SUBMISSION TO SYDNEY GATEWAY ROAD PROJECT SSI-9737

This submission has been prepared by Qantas Airways Limited and the Qantas Group, including related bodies corporate of Qantas (**Qantas**) with assistance from Urbis Pty Ltd (**Urbis**) in relation to the State Significant Infrastructure Application (**SSIA**) and preliminary draft Major Development Plan (**MDP**) for the Sydney Gateway Road Project (**Gateway Project**).

Figure 10.3 Predicted worst-case impacts 'other sensitive' receivers

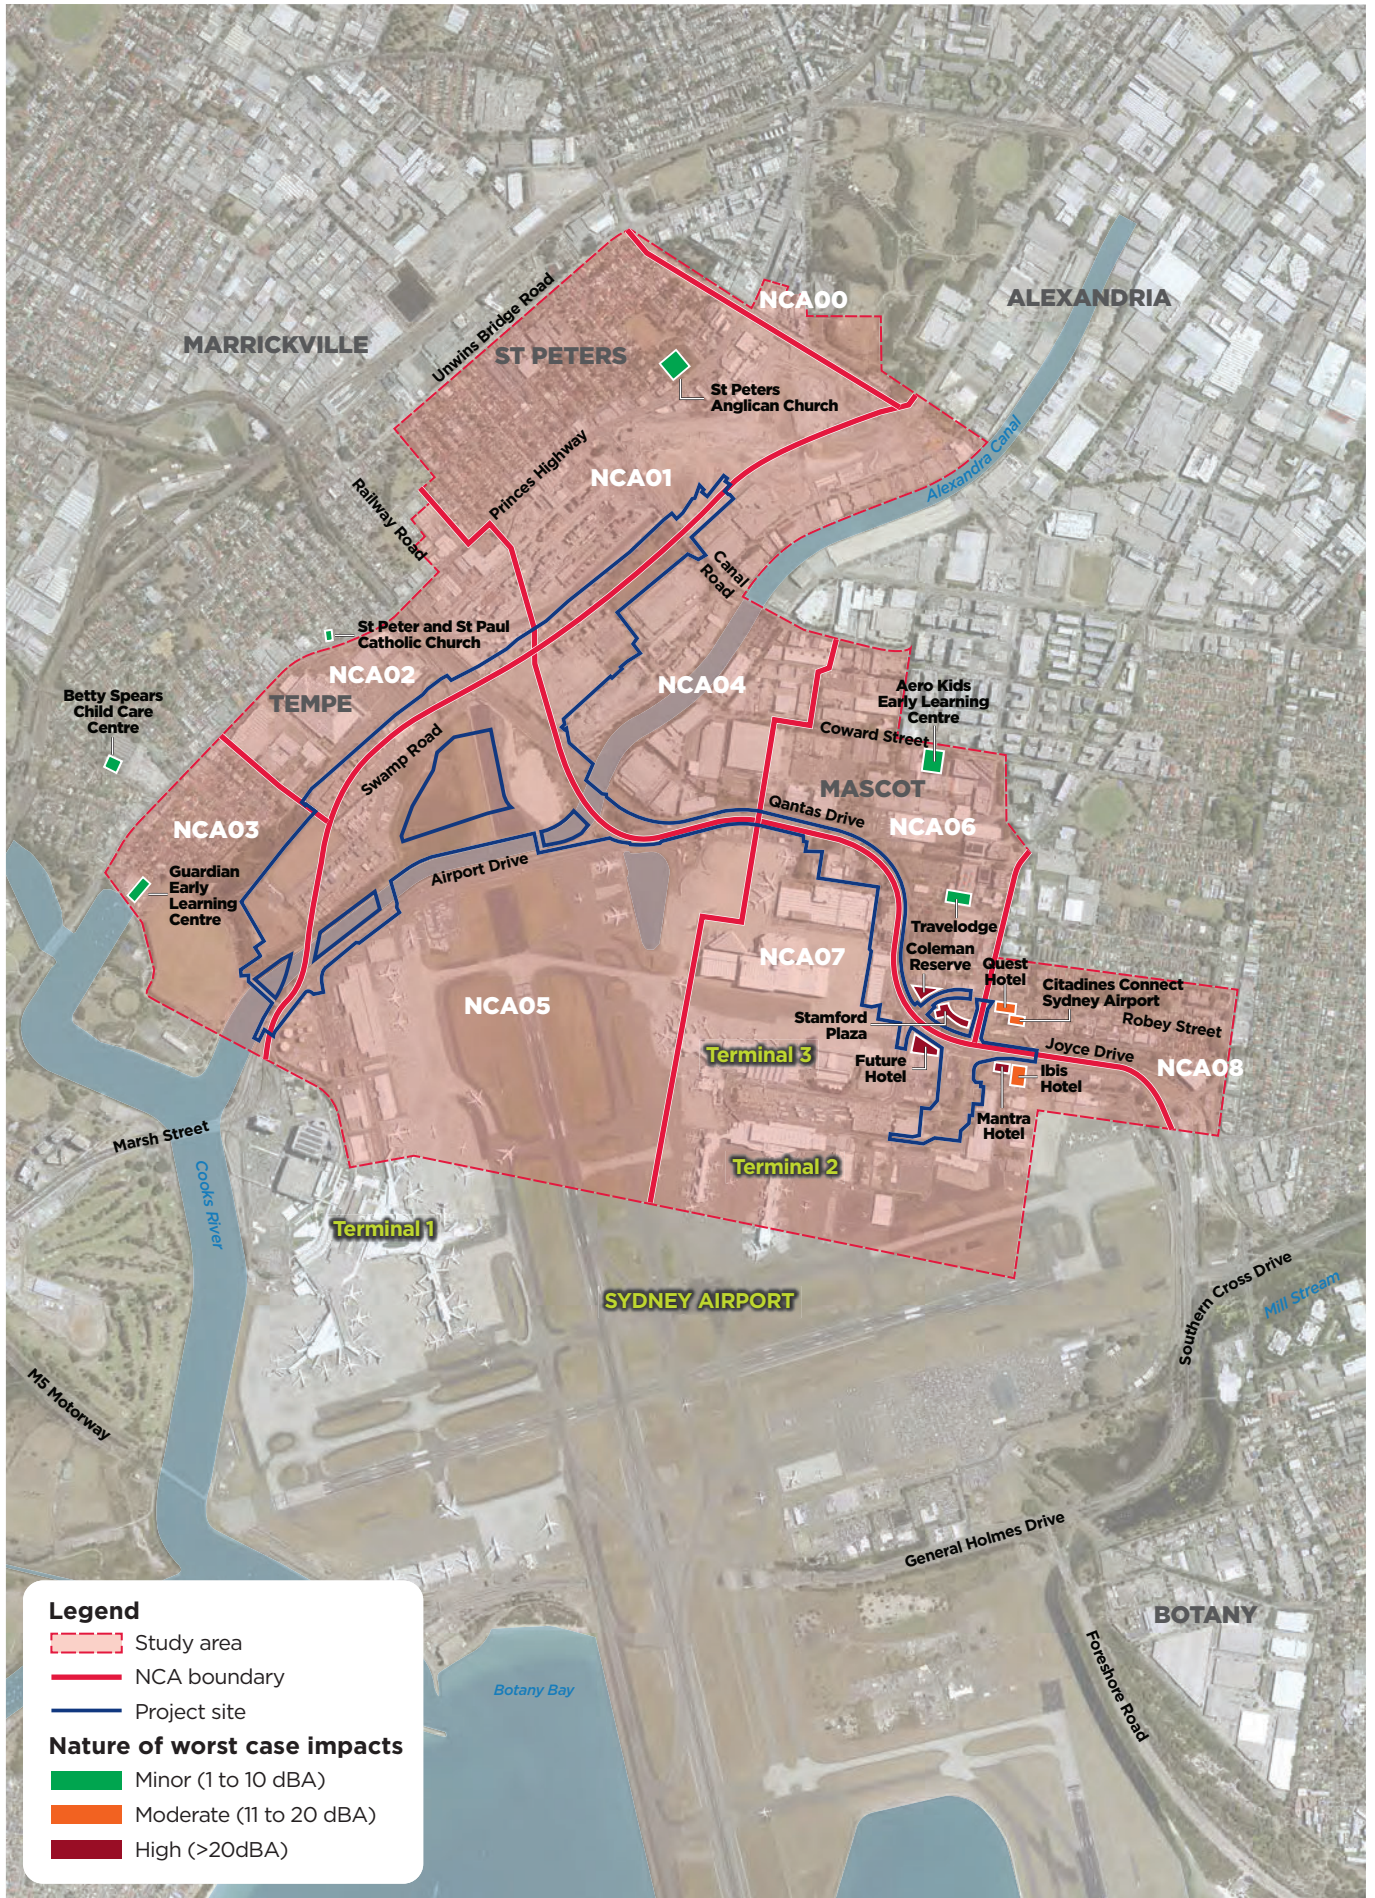
As per NDY's advice (**Attachment A**), the Noise and Vibration TWP identifies in Section 5.5.2 that at times the noise impacts on the existing Flight Training Centre may be "high", implying a >20dB exceedance of a 45 dBA internal noise criteria and a conservative 10dB reduction from outside to inside. The external peak levels are clarified at 75-90 dBA for works directly adjacent to the existing Flight Training Centre, with impacts reducing to less than 70 dBA for works of >100m distance. For ground-borne noise, impacts are also predicted to be "high" in the worst case.

The Qantas Flight Training Centre operates 24 hours a day, 7 days a week. These predicted high noise levels could potentially prejudice Qantas' ability to maintain a functioning and compliant Flight Training Centre. As indicated in the NDY advice (**Attachment A**), the most critical pilot training activities can be affected by individual noise events rather than cumulative/ average noise levels. As such, the maximum predicted noise level (L_{max} level) for the new Qantas Flight Training Centre, which is a key metric for Qantas, should be clearly stated in the Noise and Vibration TWP to allow Qantas to review and assess the impacts.

Qantas requests an amended EIS be prepared for the SSIA/MDP where:

- Both the existing and new Qantas Flight Training Centres are identified as Sensitive Receivers and new noise and vibration assessments are undertaken by TfNSW in consultation with Qantas;

- Any approval granted for the Gateway Project contains explicit conditions that place maximum noise and vibration limits on the Gateway Project that reflect the internal noise criteria outlined in Table 1 and 2 to protect Qantas' operational requirements specific to Flight Training;

Figure 10.5 **Worst-case predicted change in operational noise levels in 2036 future design scenario**

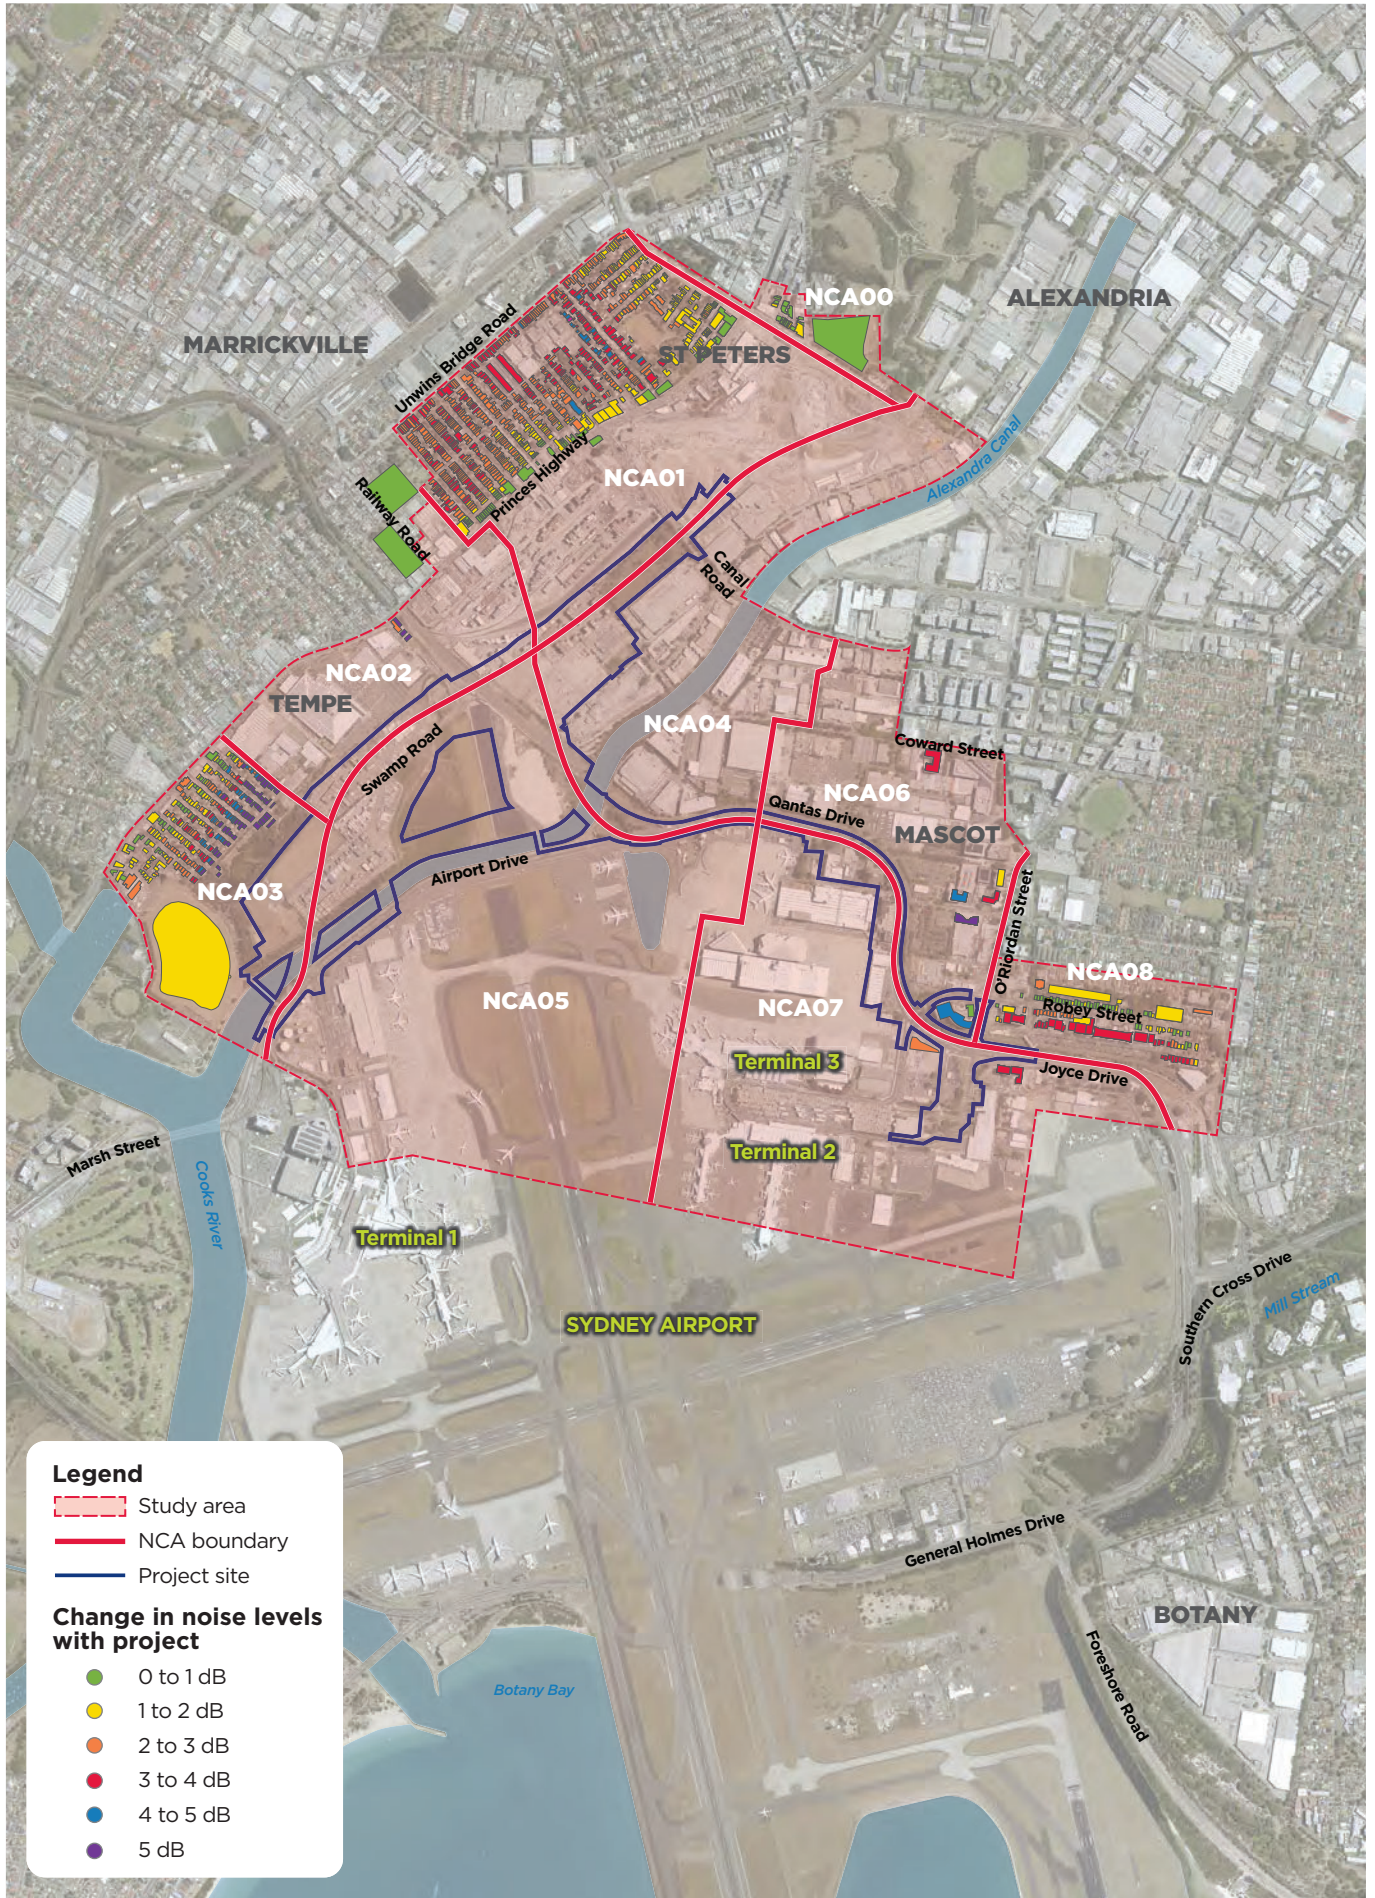
There are no specific predictions of operational noise impacts from the completed Gateway Project to the new Flight Training Centre. Graphics in the report indicate that changes to operational noise levels are likely to be less than 3dB, and that this change is not likely to significantly impact the new Flight Training Centre compared to other noise sources in the area.

Qantas requests that more information is provided to confirm the operational noise impacts from the completed Gateway Project.
